CITY OF PORTLAND NOTICE OF VIOLATION

RE: 75 Deepwood Drive
CBL: 397-C-012, Zone - R2, Building Permit # 05-1331

75 DEEP WOOD DRIVE

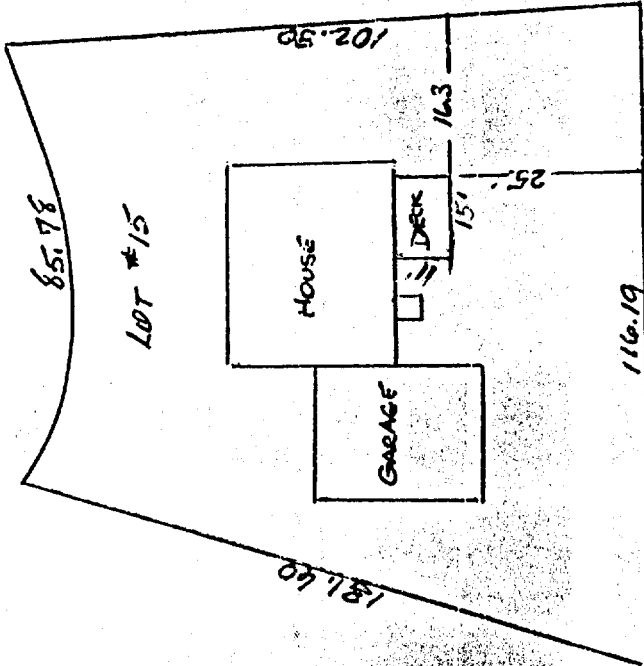
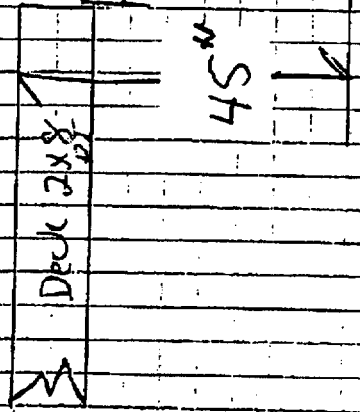
Section 14-80: The R-2 Residential Code requires twenty-five (25) feet as a rear setback to the property line, the measured distance to the new sunroom and deck is fifteen (15) feet to the survey pin.

Failed to schedule for the required inspections. All property lines shall be identified to determine setback compliance. The deck and part of the sunroom are non-conforming.

This is a Notice of Violation pursuant to Section R113.2 of the Building Code. The referenced setback violation shall be corrected within 30 days of the date of this notice. Please remove the structures or apply for a building permit to modify the structure to show conformance to the rear setback. Failure to comply will result in this office referring the matter to the City of Portland Corporation Counsel for legal action and possible civil penalties, as provided for in Chapter 1-15 of the Code and in Title 30-M.S.R.A. ss4452.
